DRB Project Number: PR-2023-009105 Hearing Date: 05-07-2025
2A, 2B, COTTONWOOD
CROSSING PHASE 2, located on
10088 COORS BLVD NW
between 7 BAR LOOP and
Project: COORS BLVD Agenda Item No: 3

Development Facilitation Team (DFT) – Review Comments

Project No: PR-2023-009105 Date: 5/07/2025 Agenda Item: #3 Zone Atlas Page: B-14

Application For: VAC-2025-00018 – VACATION OF PUBLIC EASEMENT

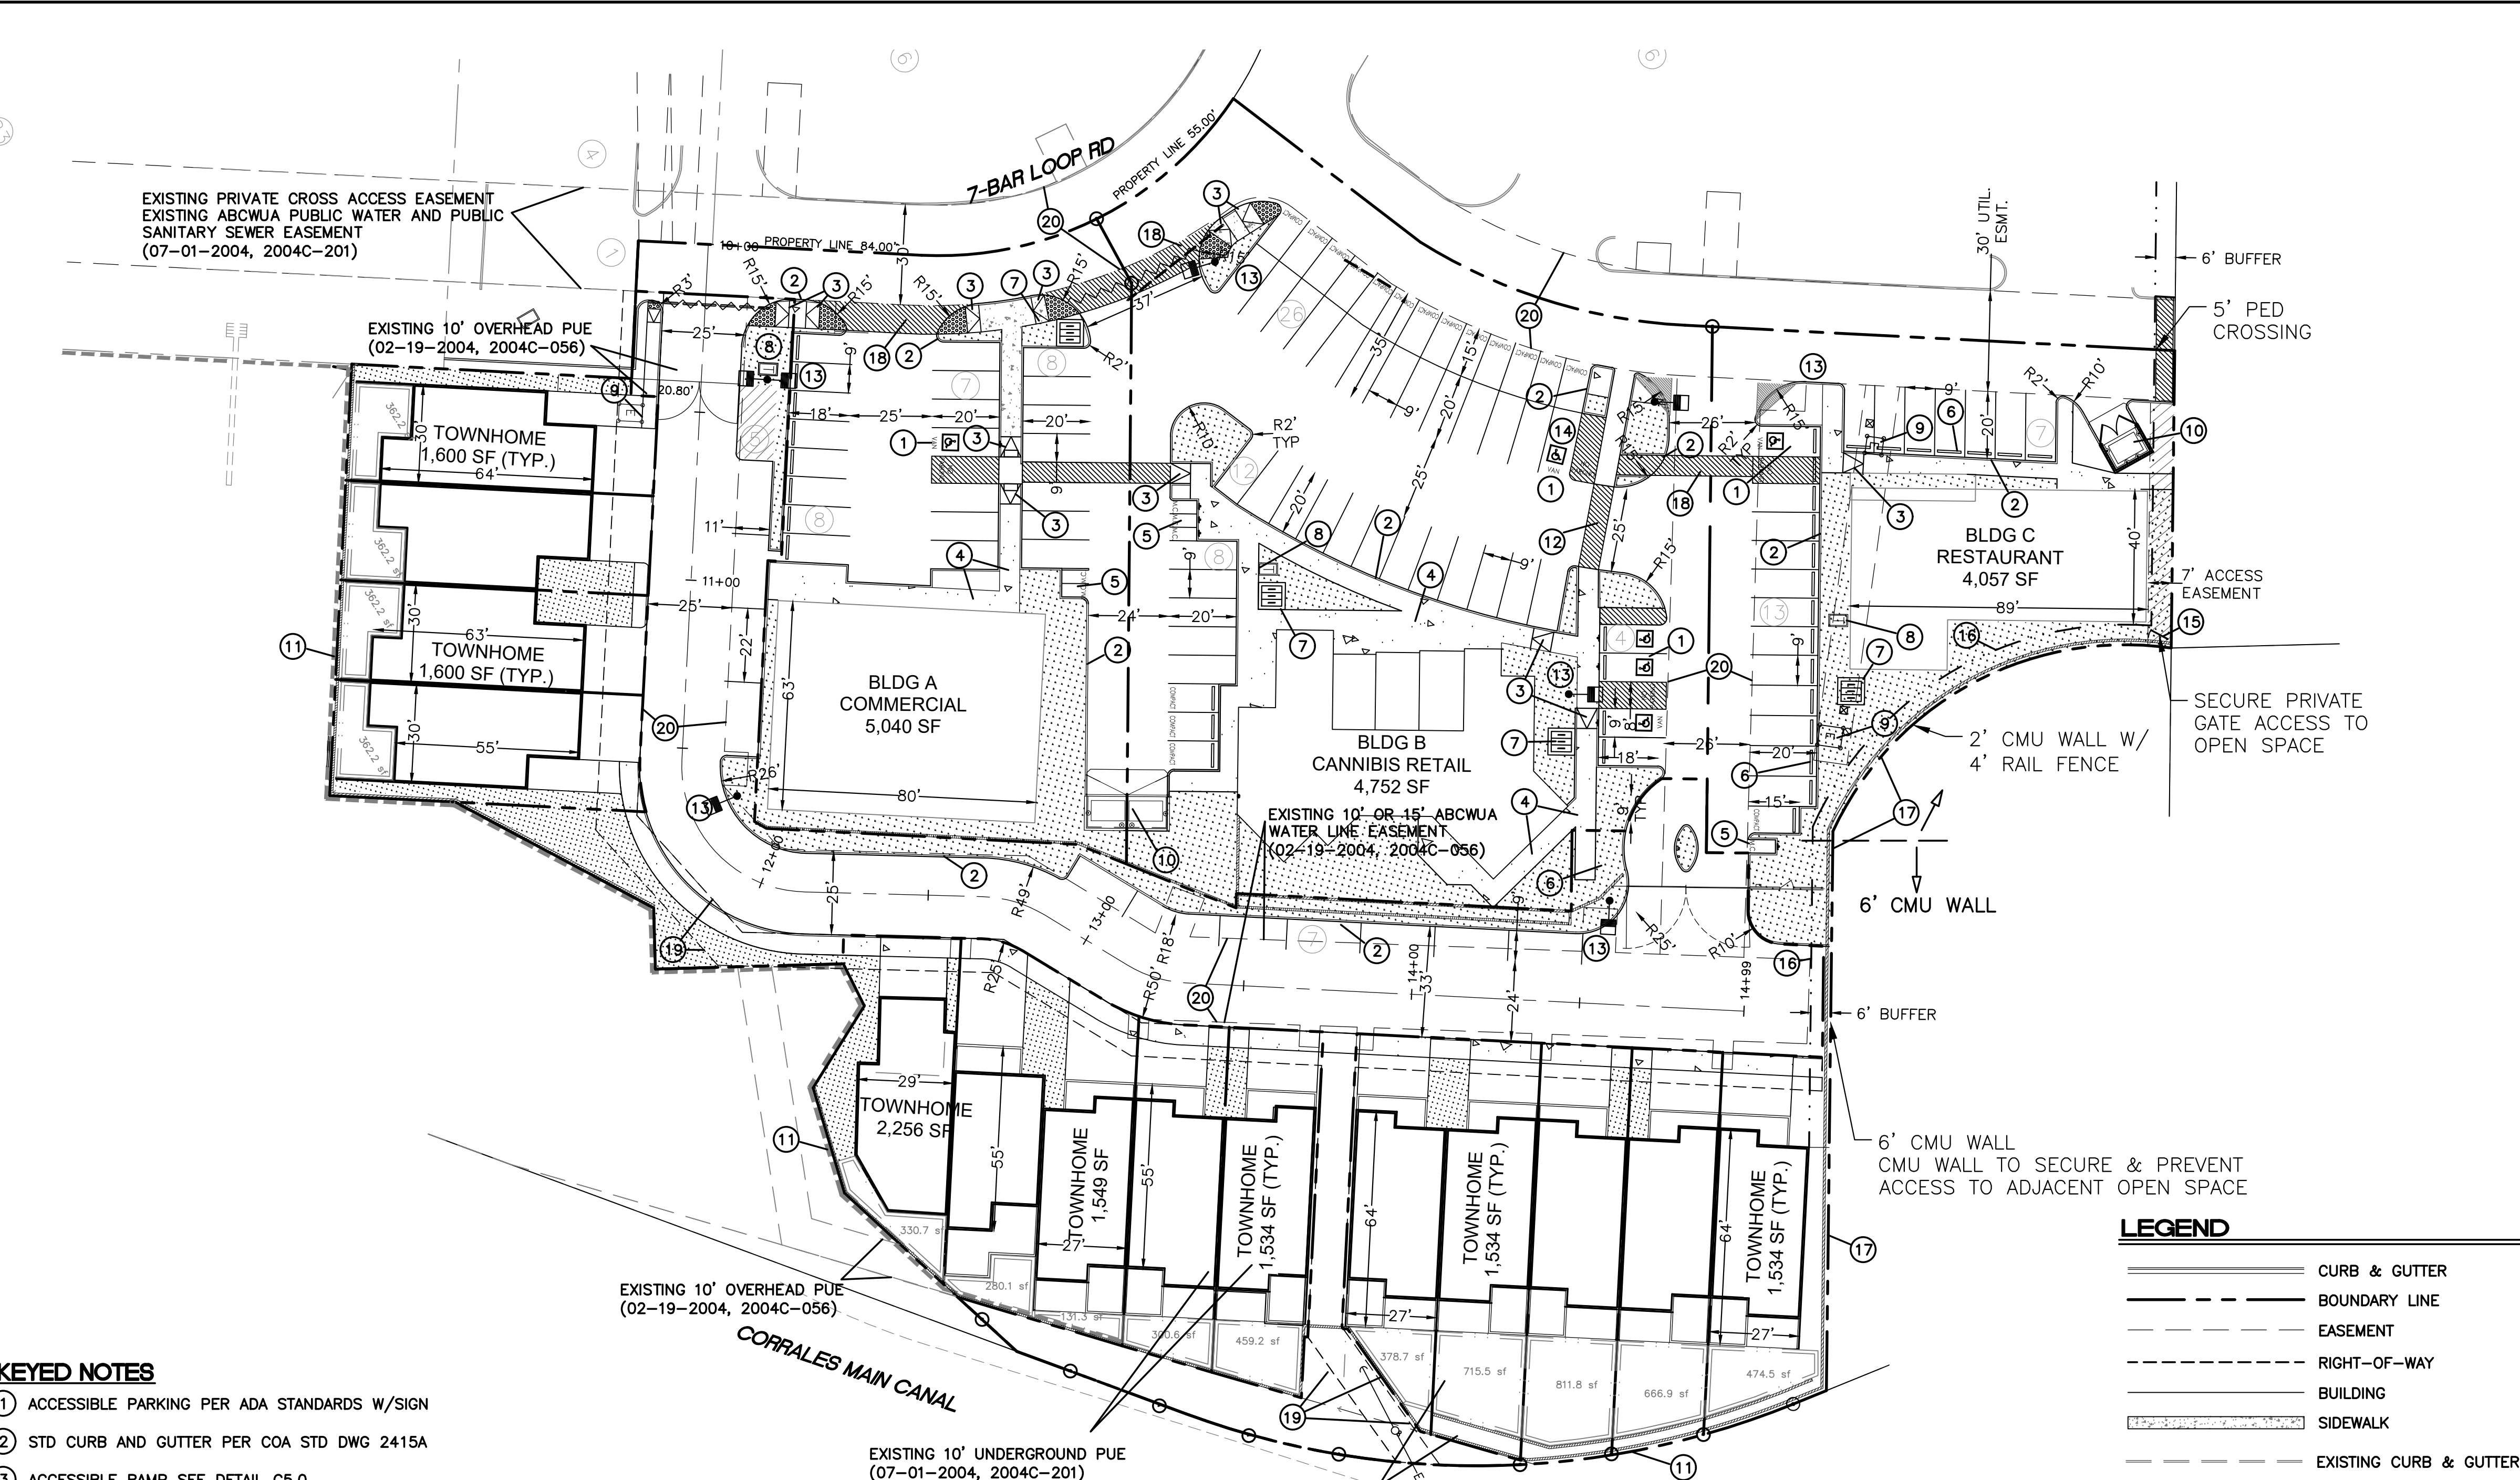
The site is adjacent to MPOS (Black Ranch) and within 330 ft of MPOS. The application states that there was an EPC Variance requested for MPOS buffer. What was the variance allowance?

What was the EPC variance for the MPOS buffer?
